March 4th, 2013

Project Name: **Old Barn Estates 16 Lot Subdivision**
Project ID: 2012-584; CBL: 414-A-4 (and part within Town of Falmouth)
Address: 1062 Ocean Avenue (Ledgewood Drive)
Applicant: Tim O'Donovan, TPO Properties LLC
Planner: Jean Fraser

TO: Jean Fraser, Planner
FROM: David Senus, P.E.
DATE: February 20, 2013
RE: Final Level III Site Plan Application Response to Comments – Old Barn Estates

S-101

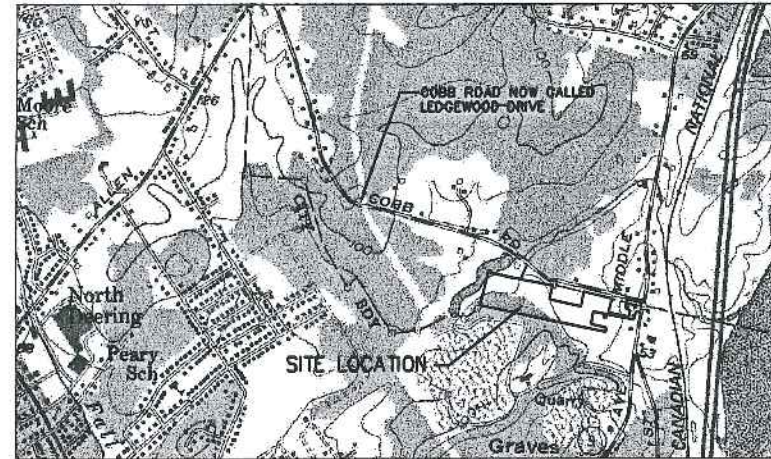
5. *Comment: Sheet S-101, Note 15 states that "Tree save areas and stormwater buffer areas shall be identified on the ground with capped rebar pins and signage as shown on Plan C-101"; however, C-101 does not specifically call out the rebar pins or signage.*

Applicant Response: Tree save and stormwater buffer areas are now identified on Plan C-101 showing location of rebar pins and signage. Also see note #15.

Although there appear to be symbols identifying the rebar pins and signage on C-101, these symbols are not identified within the plan legend or specifically called out on the plan. A callout for the pin and sign symbol should be added to C-101 (refer to the callouts used on S-101).

Plan 9 2nd workshop

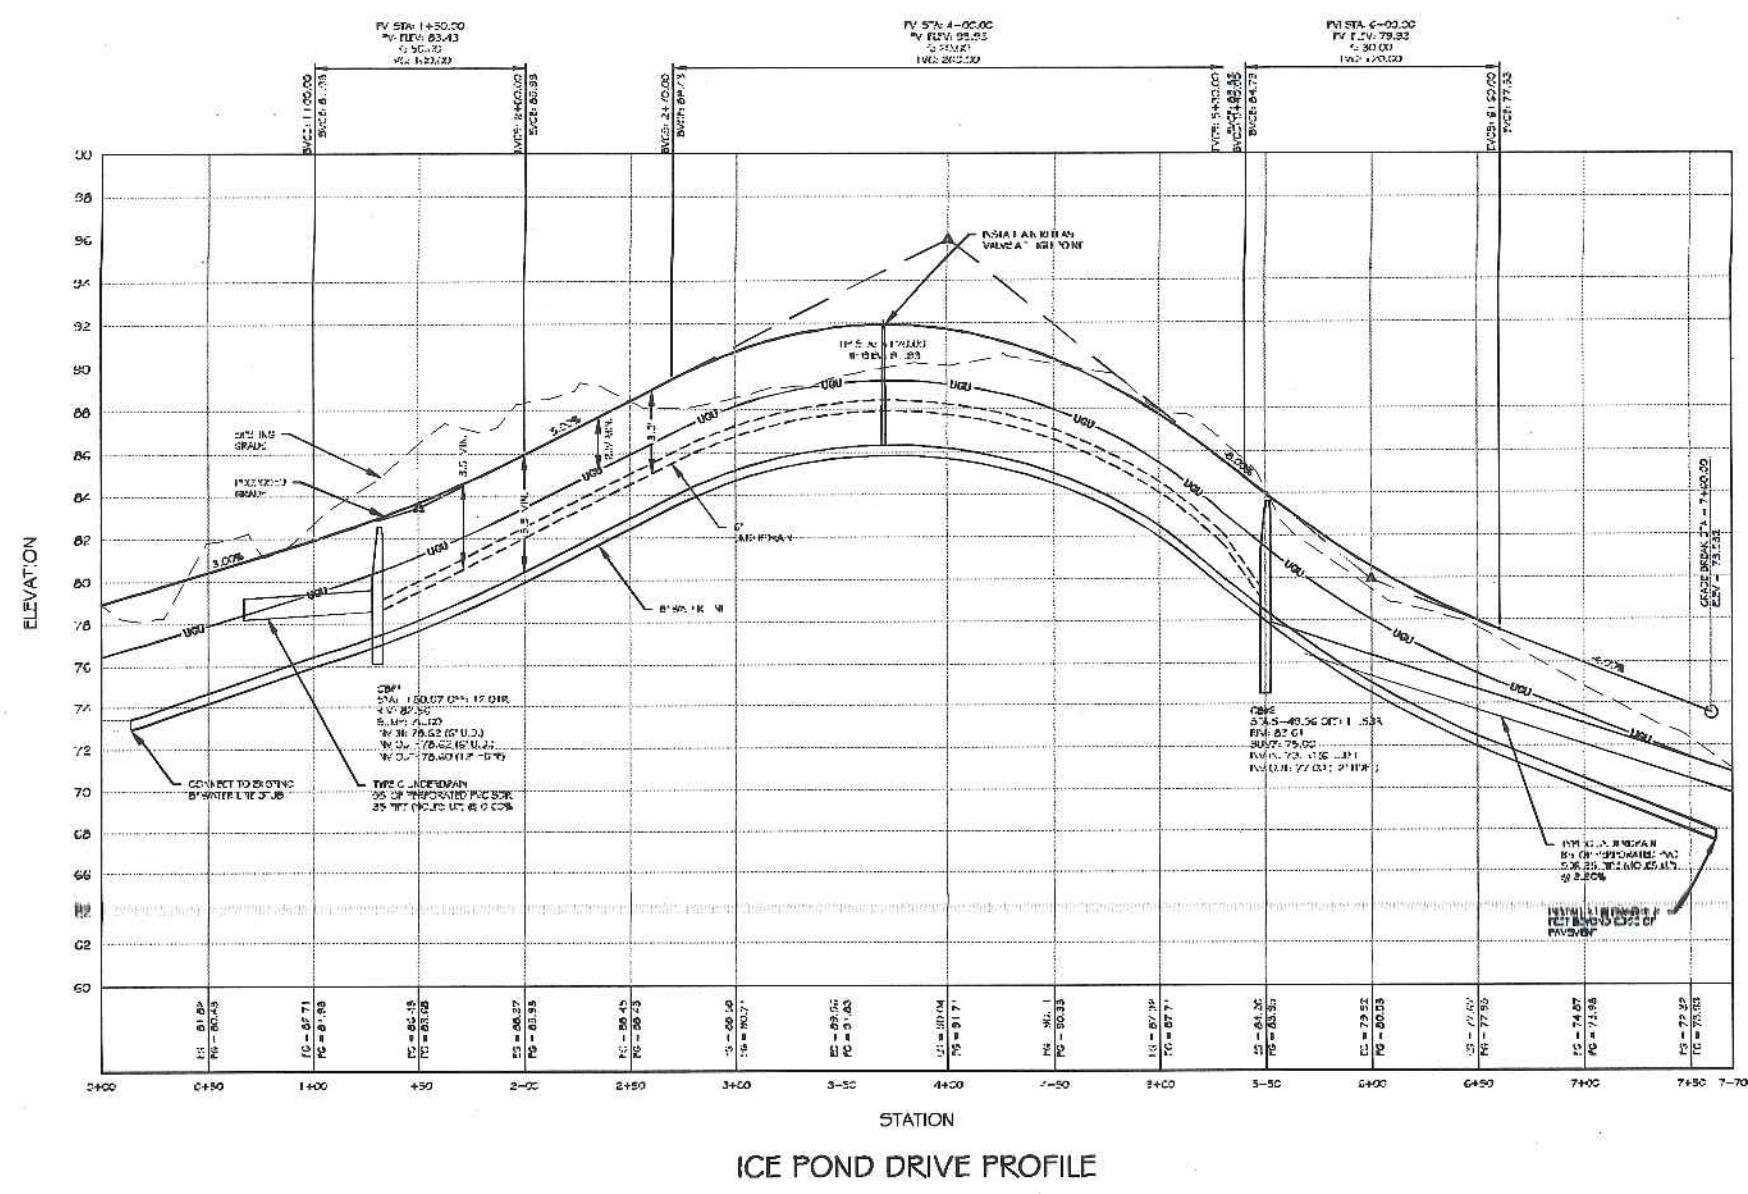
2. *Comment: The proposed culvert at STA 2+70 along the Lot 2 Driveway was modeled as a 36" diameter culvert and shown in profile as a 36" diameter culvert; however, sheet C-201 still refers to a 30" culvert in plan view.*

Applicant Response: Plan C-201 now refers to a 36" culvert as is shown on C-202.

Comment adequately addressed.
